Re: Ballina High School Redevelopment 37-49 Swift Street, Ballina (SSD 7742)

Ballina High School Redevelopment (SSD 7742) – Response to Notice of Exhibition

PROJECT No: 10806 PHASE: DA DRAWING No: A-100 REV: H

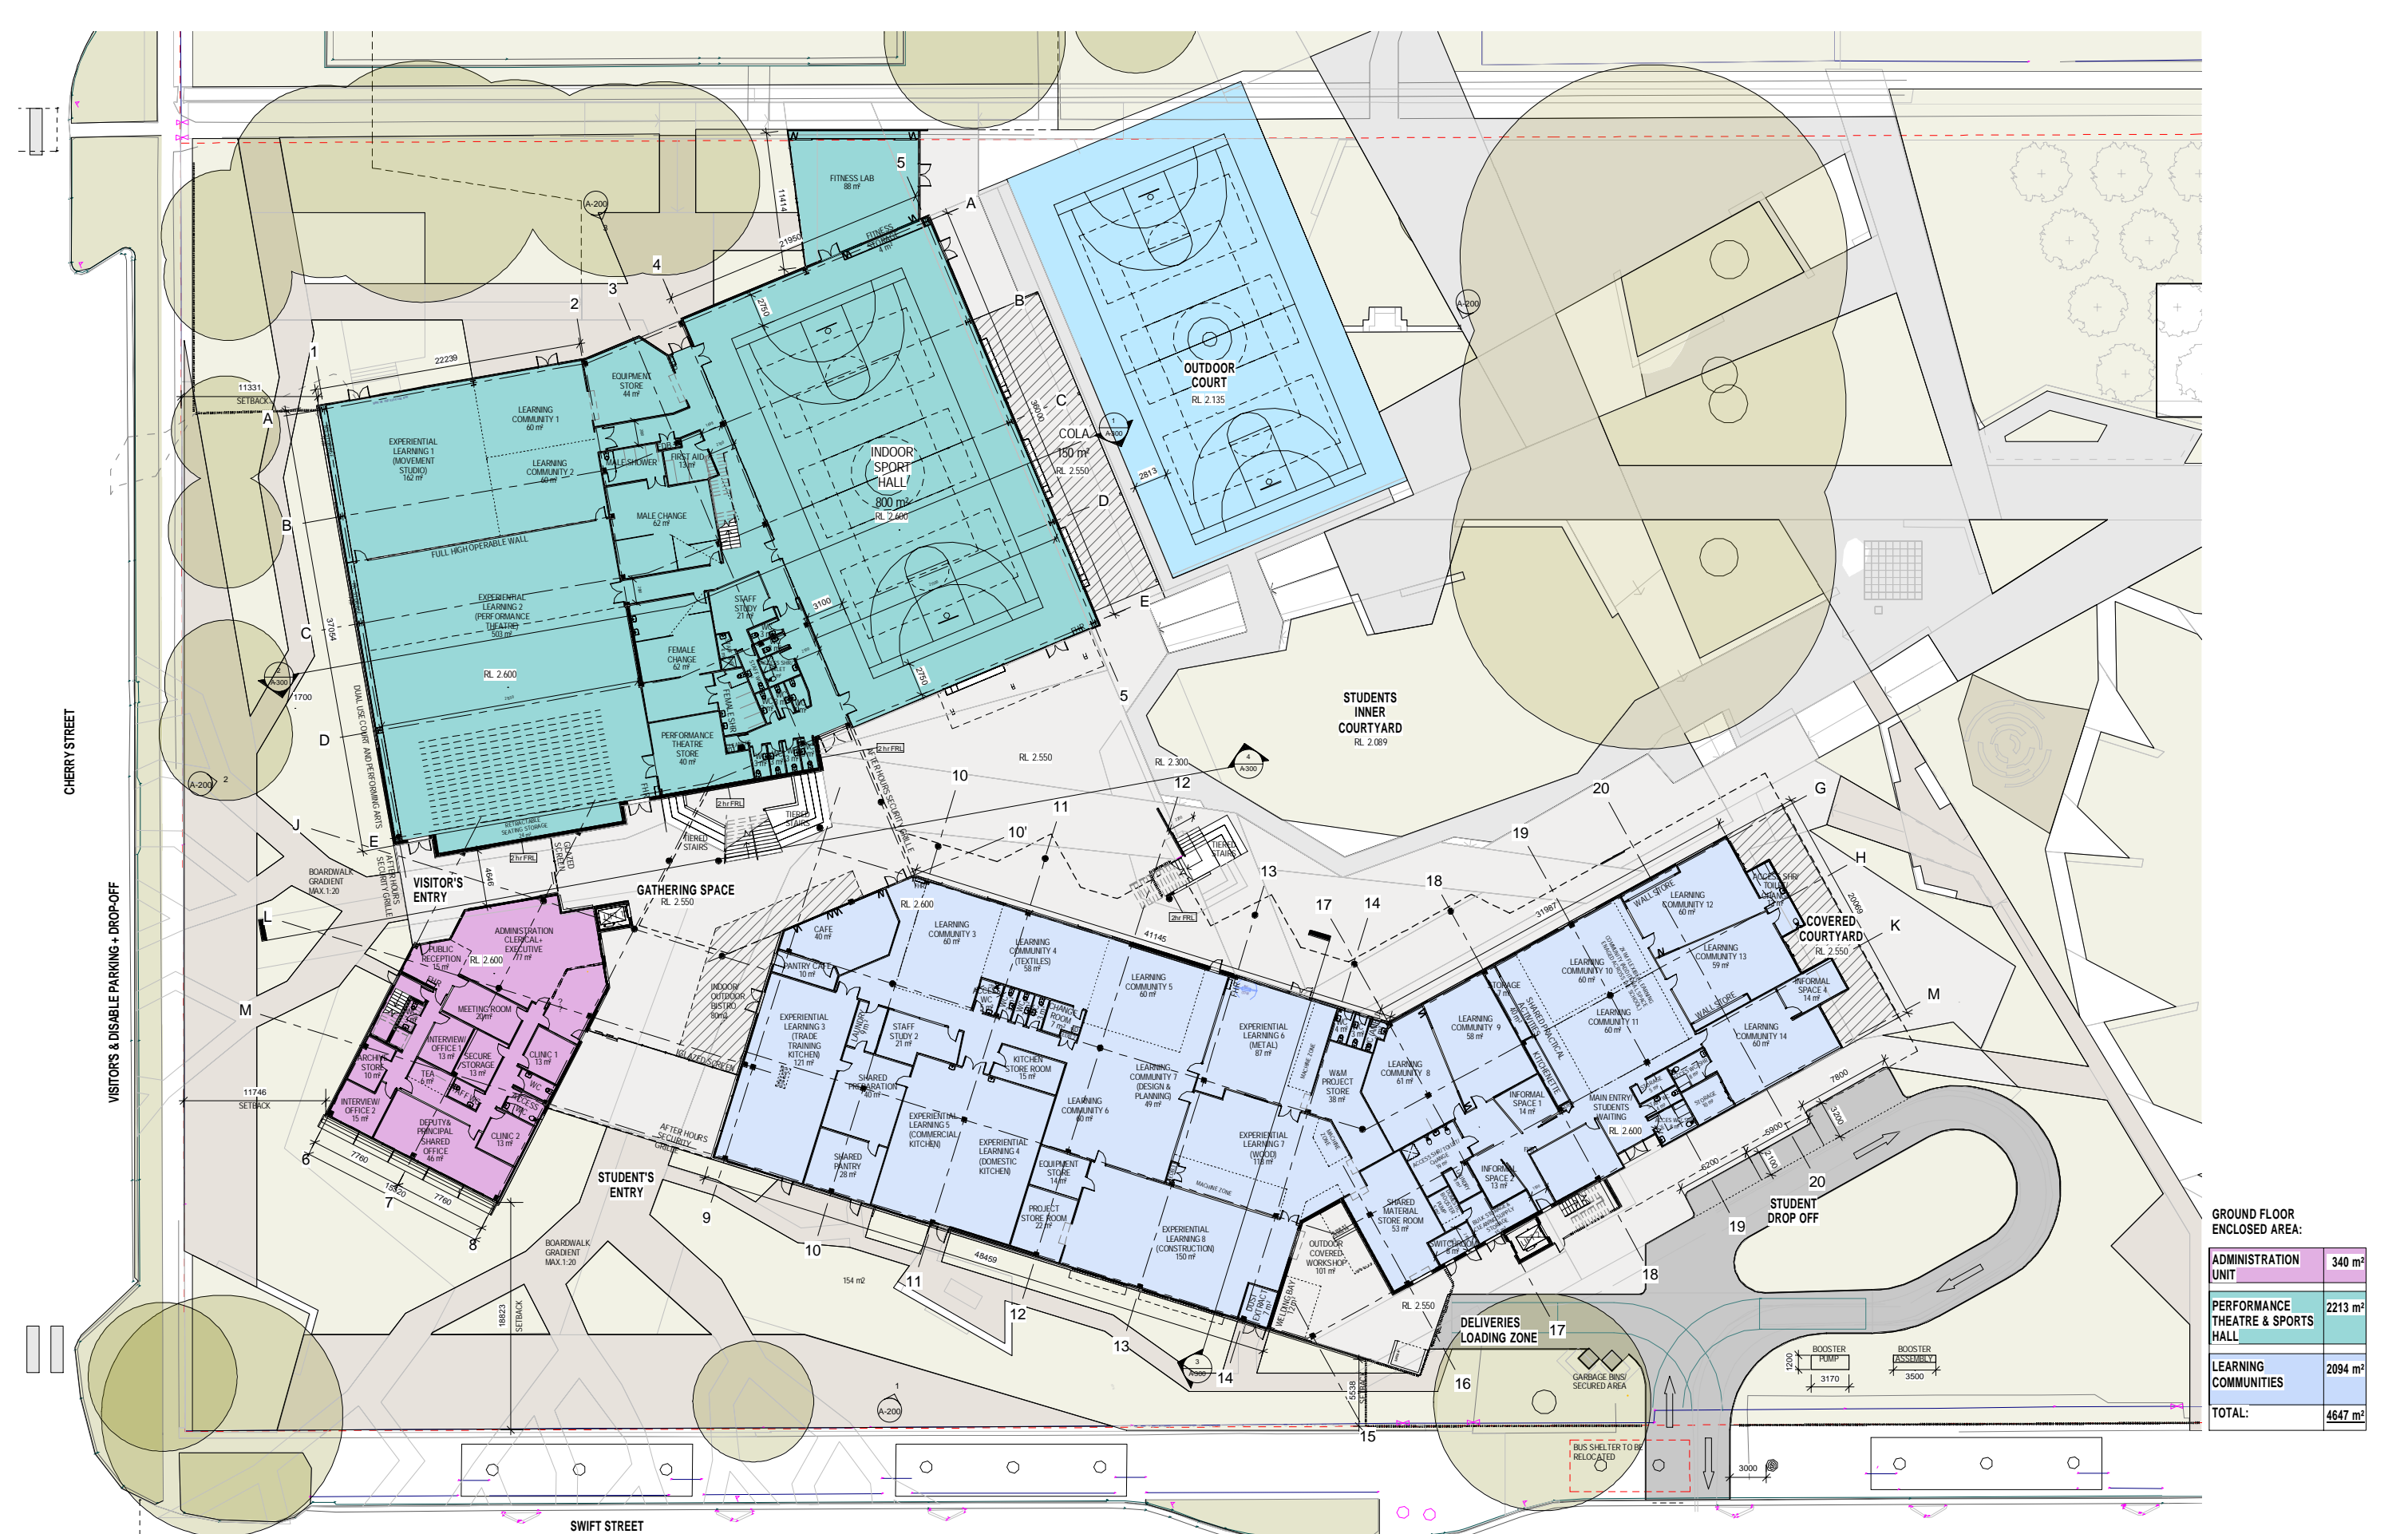
- The loading zone accessed from Swift Street is designed so that vehicles will reverse into the loading bay. The loading zone is combined with a student set down area as shown in drawing no. A100 prepared by EJE Architecture. For safety reasons, loading zones, particularly with reversing heavy vehicles should be physically separated from pedestrians.
